**COLORADO**  
**Department of Transportation**

June 4, 2020

RE: Trails at Aspen Ridge Filing #2 (Springs East at Waterview) - EA-SF1927

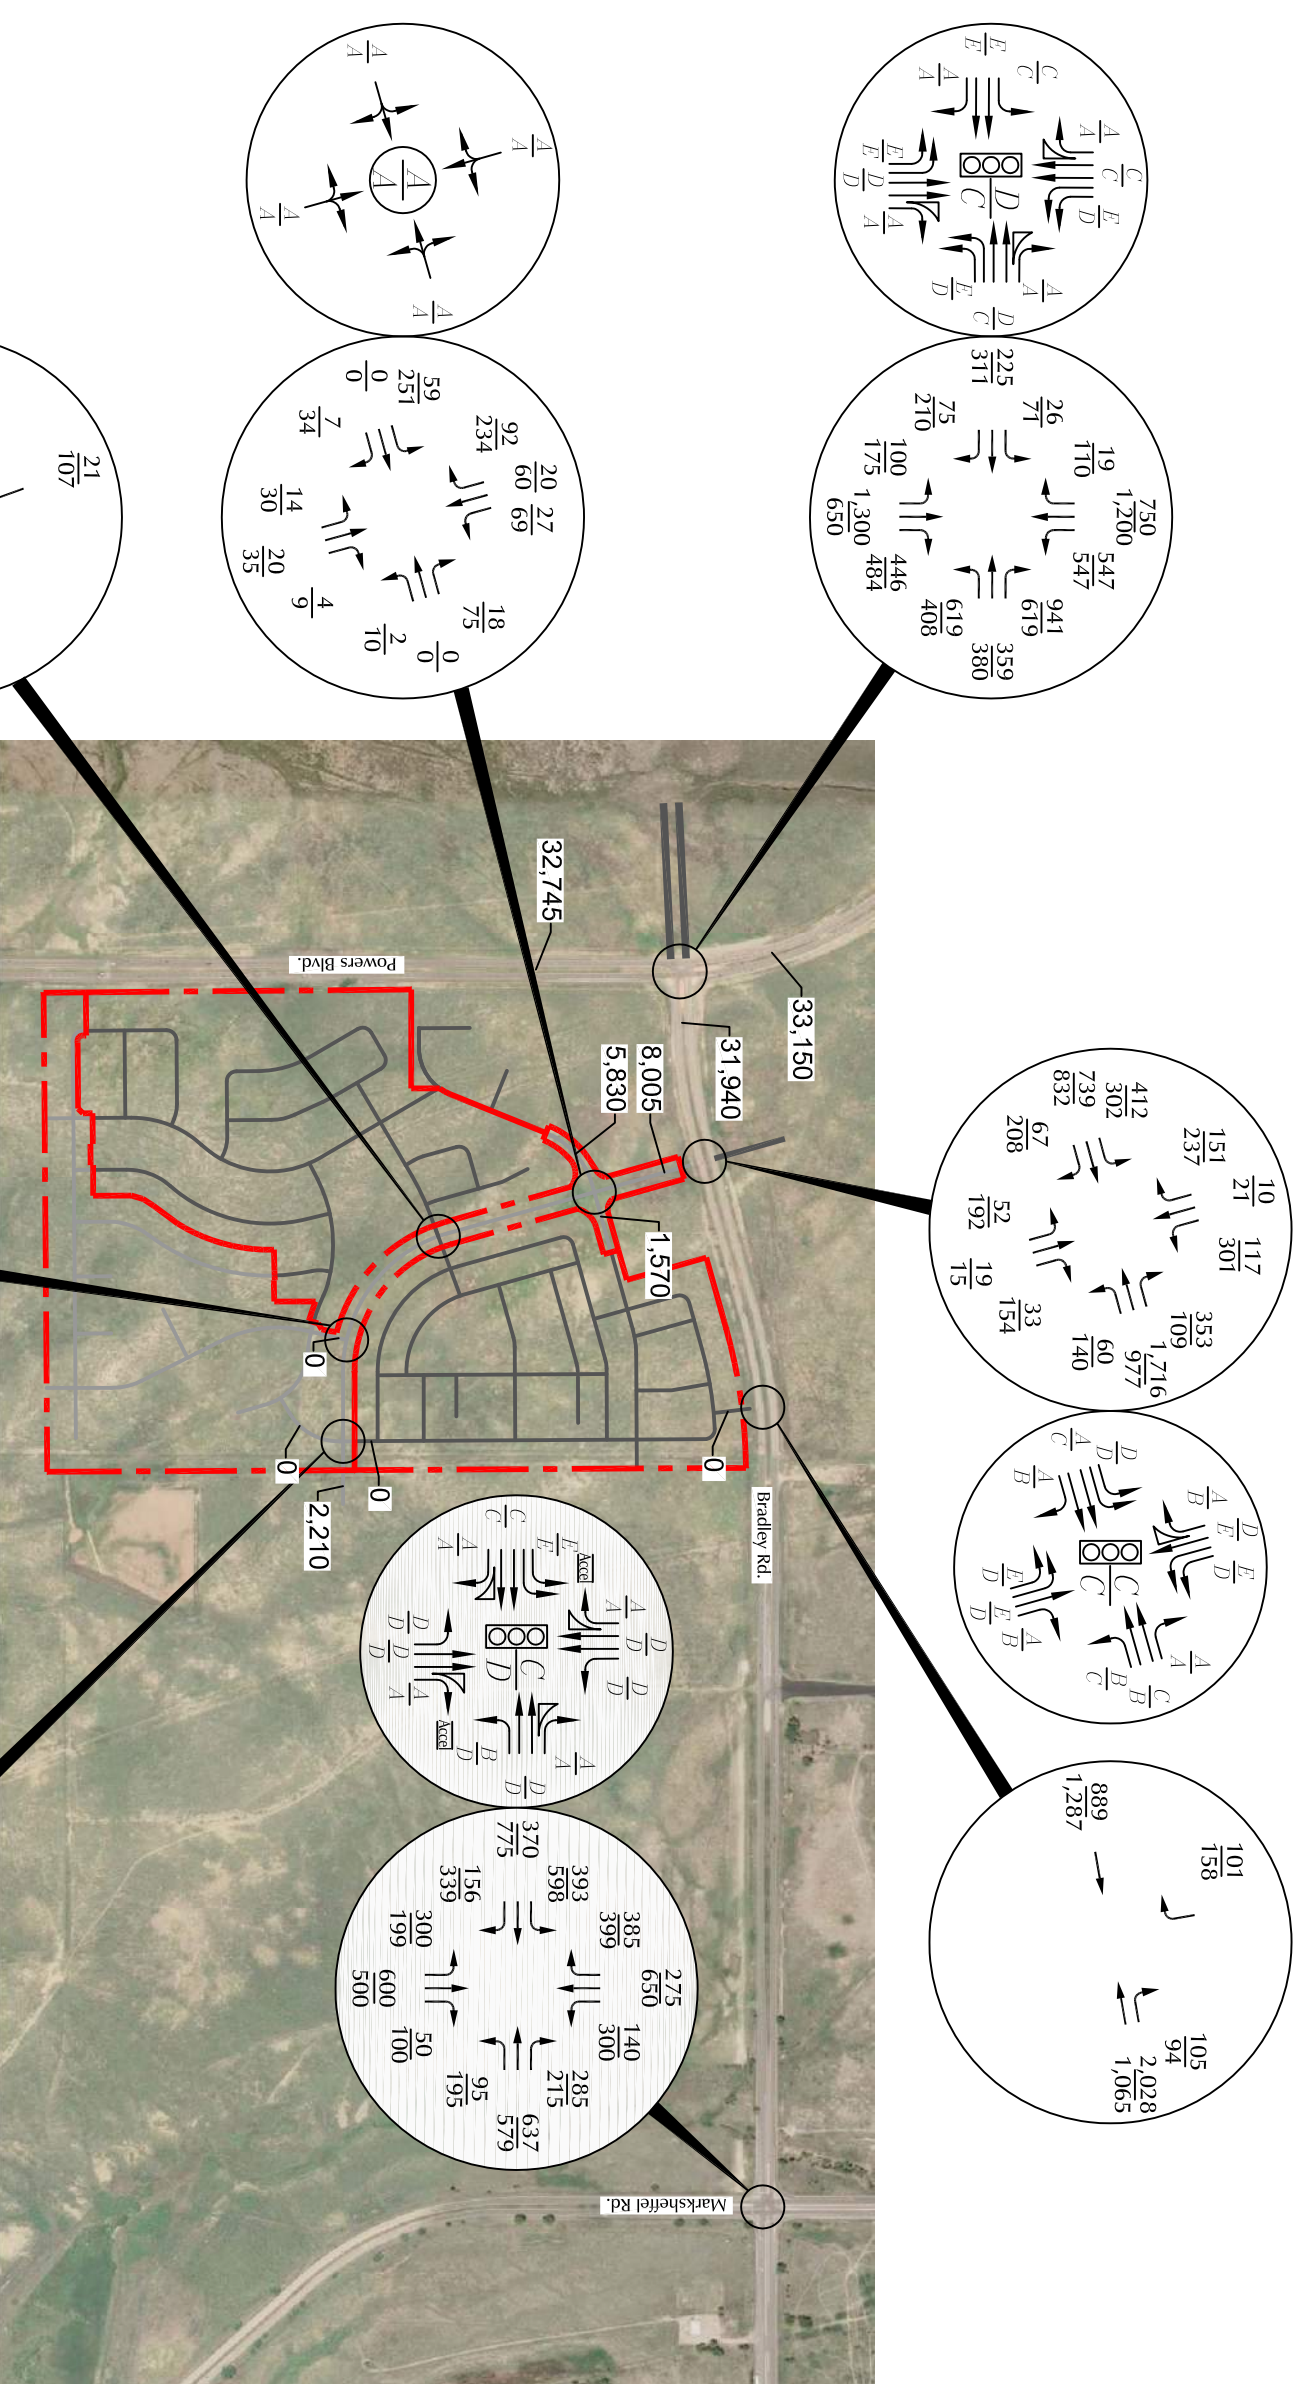
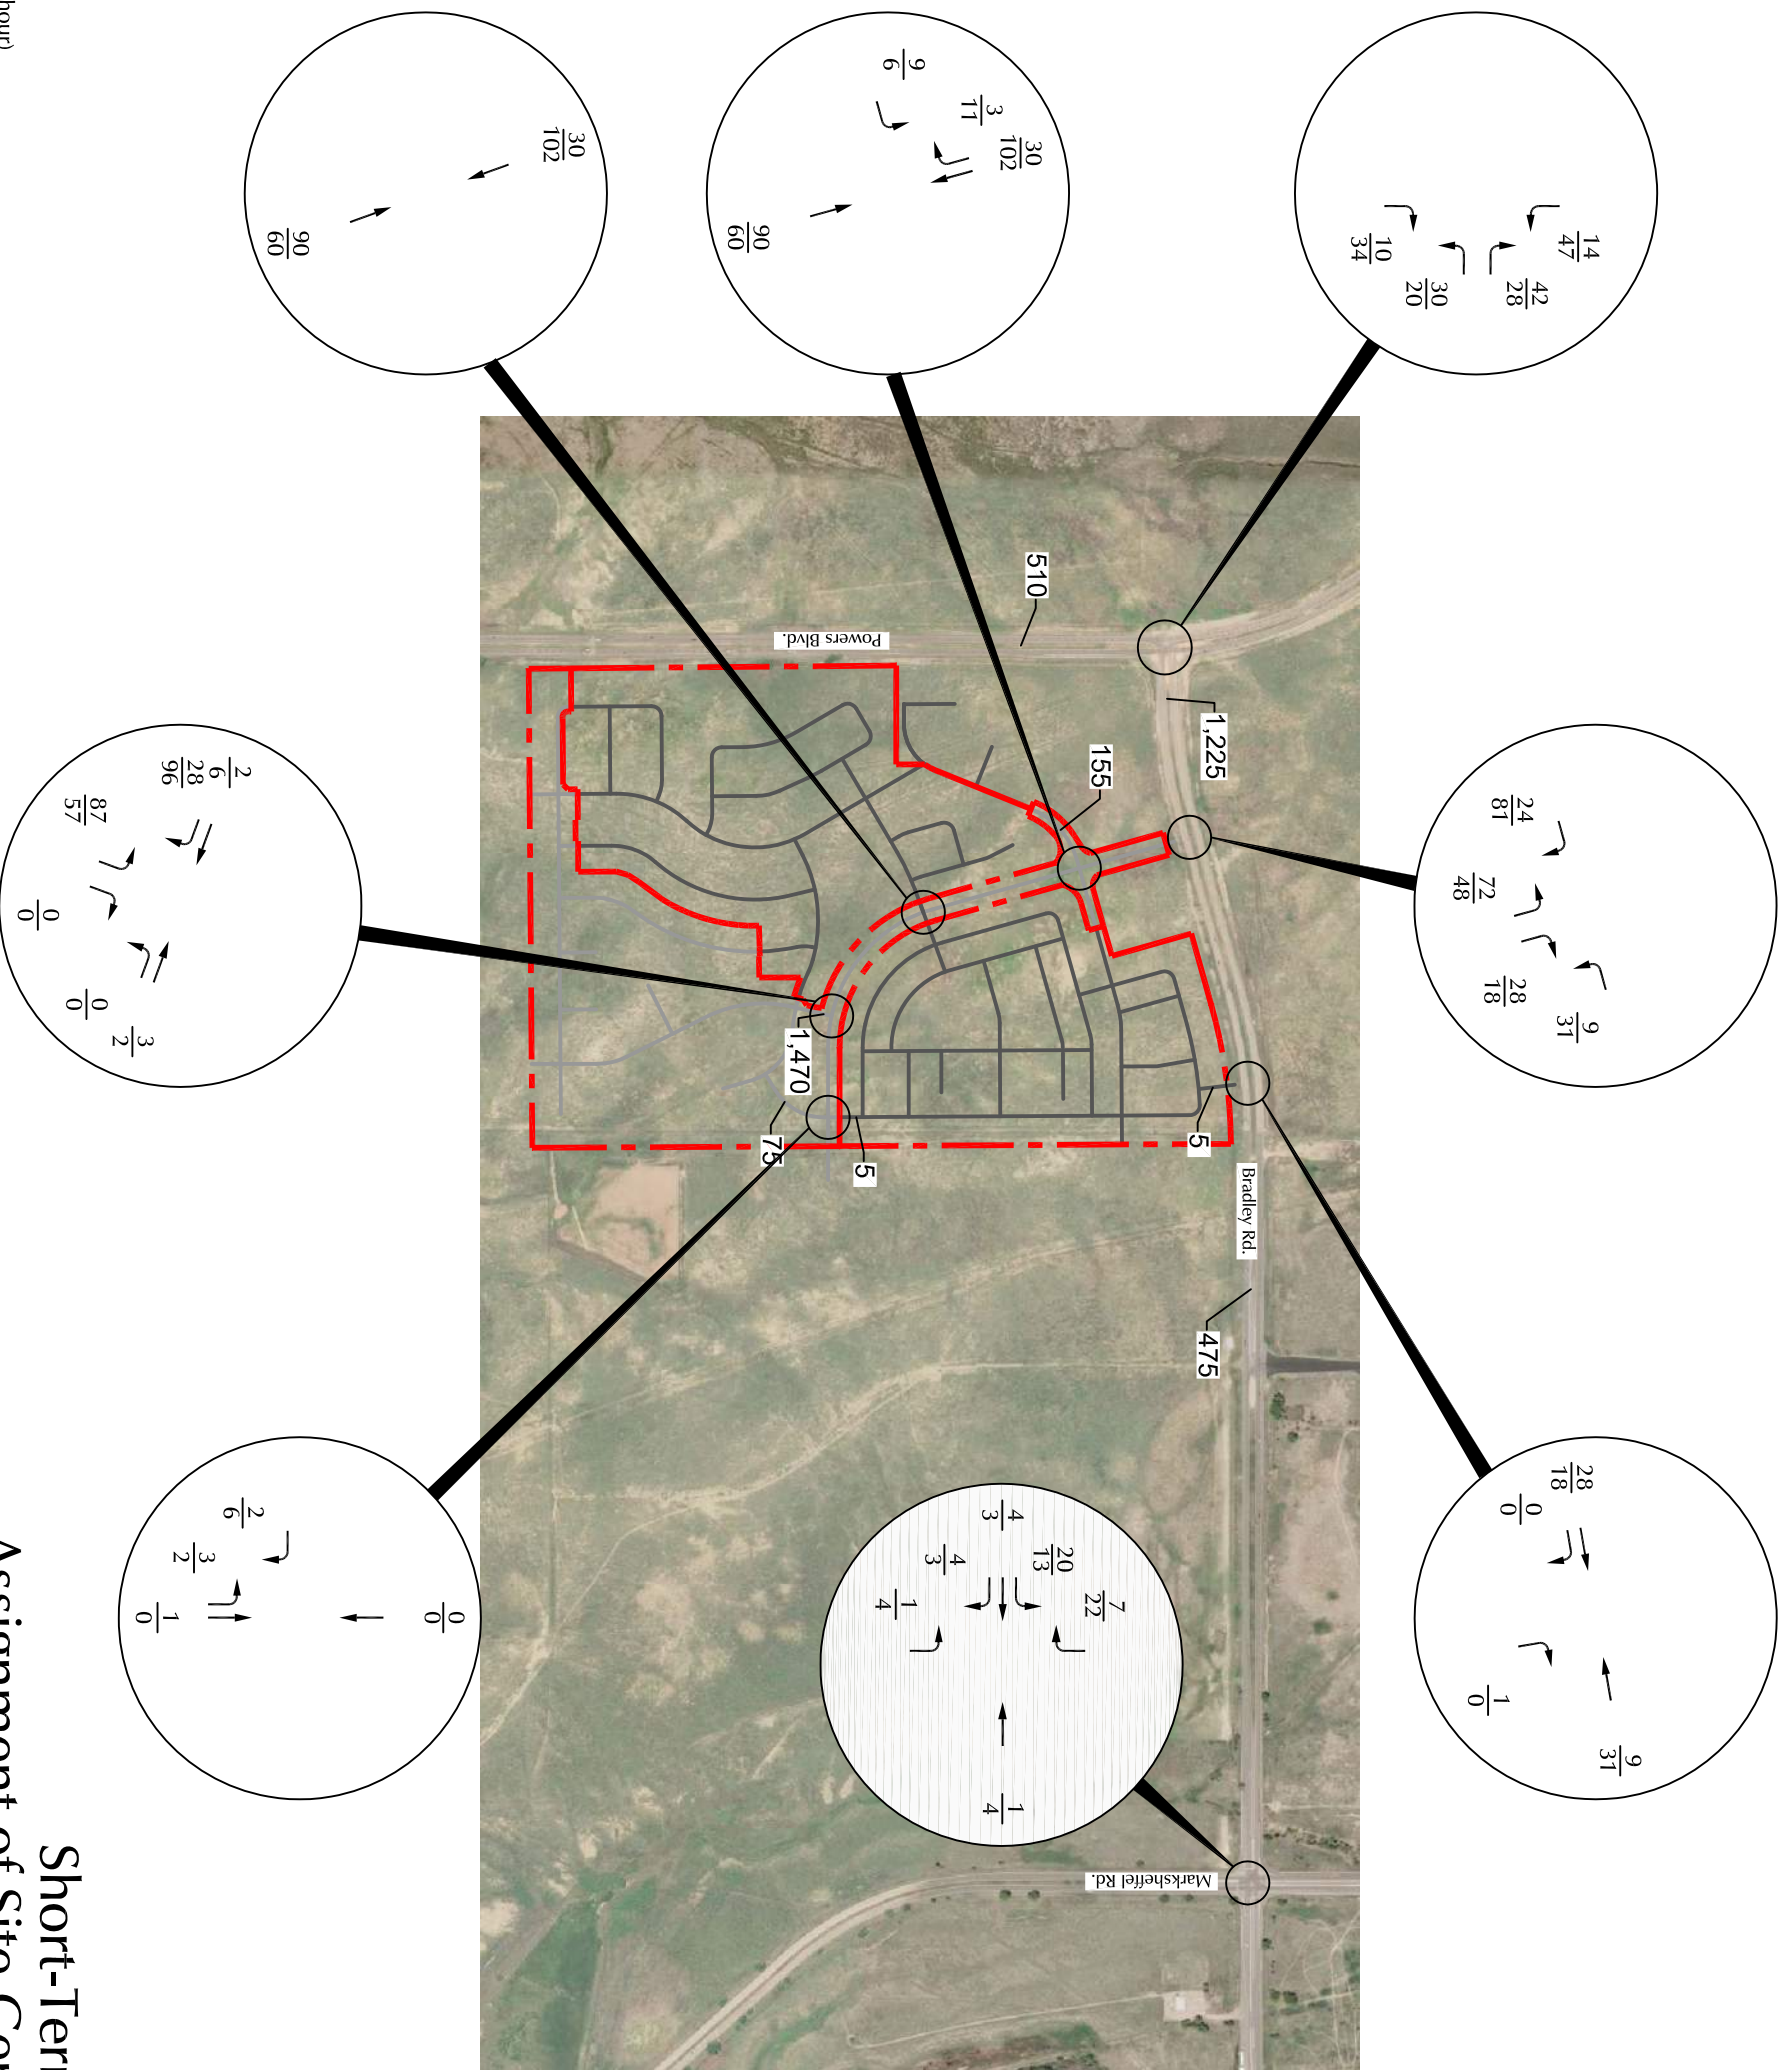
- g. The 2040 Synchro reports for Powers Blvd. Interchange Northbound Ramp at Bradley Rd is missing the existing left turn traffic in both time periods from Figure 13. Please update Figure 13.
